# Rezoning Transportation Analysis

Petition Number: #2022-091

## Revision Log:

Date	Description
11-28-22	First Review (IW)
01-27-23	Second Review (IW)
02-13-23	Third Review (DR)
02-22-23	Forth Review (IW)
03-28-23	Fifth Review (IW)

RZ-1.0

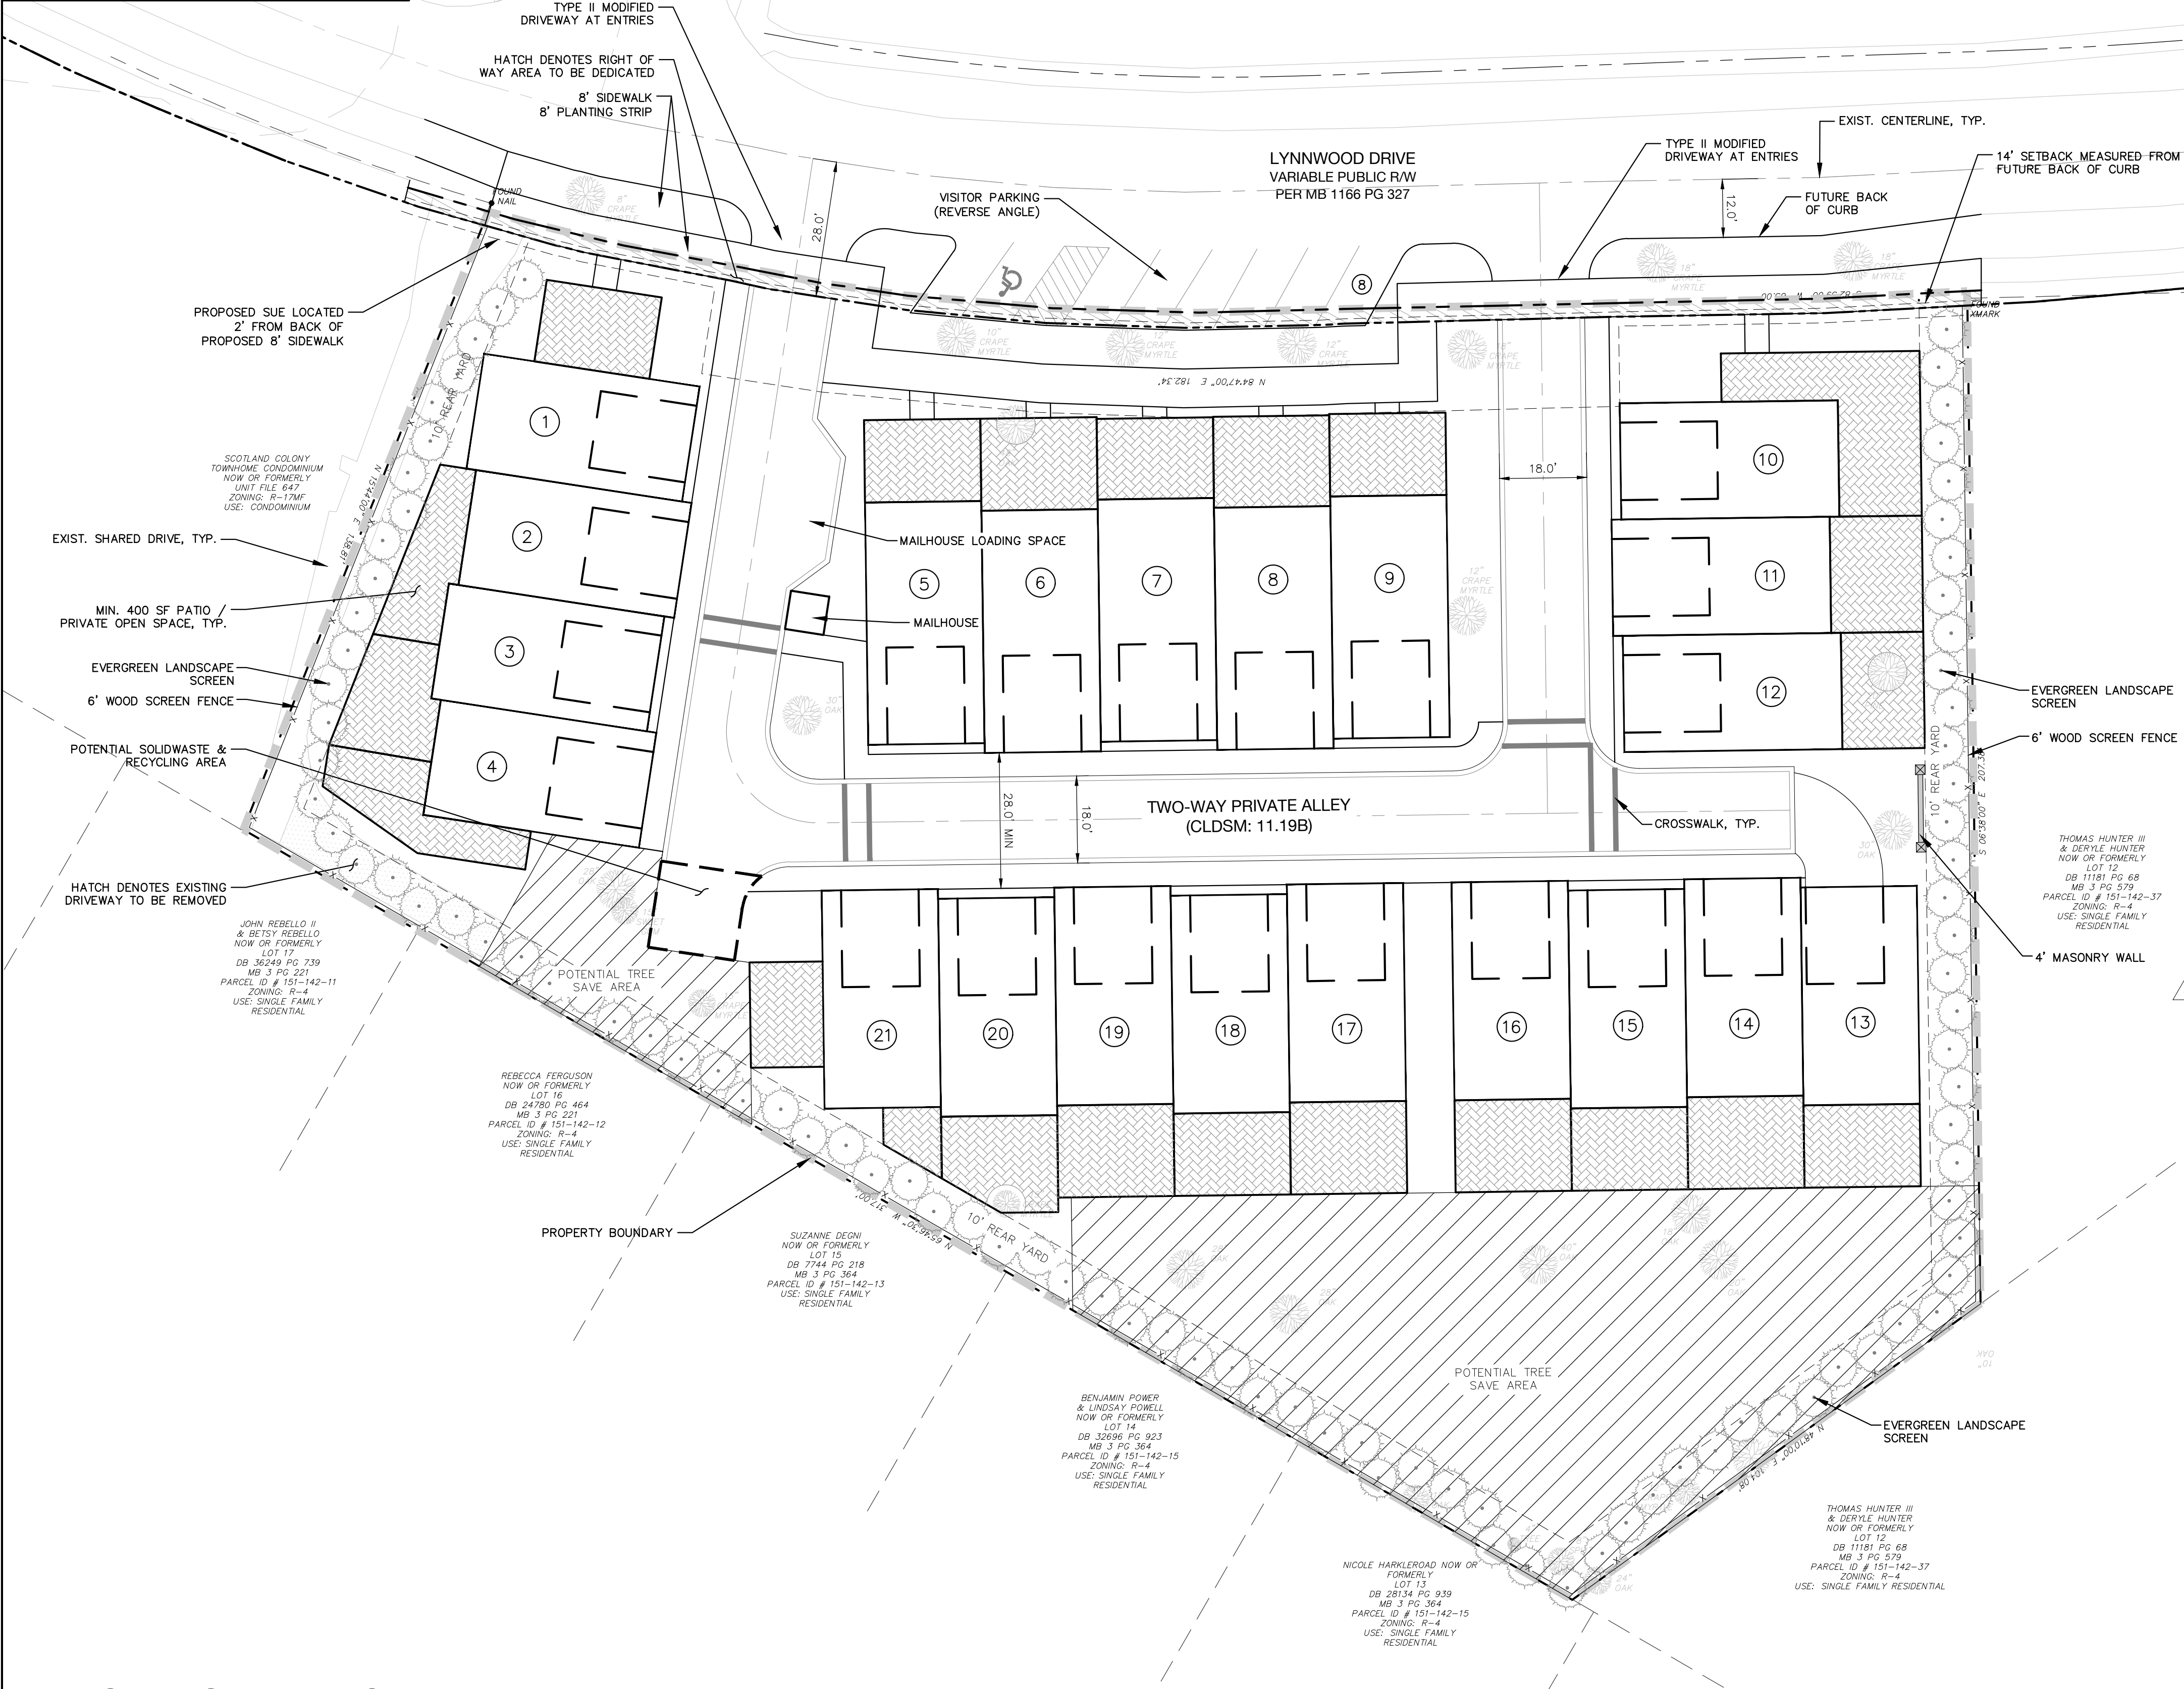
7. ~~Outstanding comment from 11-28-23:~~ A site plan note(s) specifying dedication and fee simple conveyance of all rights-of-way to the City before the site's first building certificate of occupancy is issued as needed. CDOT requests rights-of-way set at 2' behind back of sidewalk where feasible.

~~Clarifying Comment 01-27-23:~~ Site plan should update conditional note 7 under Transportation to state SUE to be 2' behind sidewalk and not 1' so that CDOT can do maintenance when necessary.
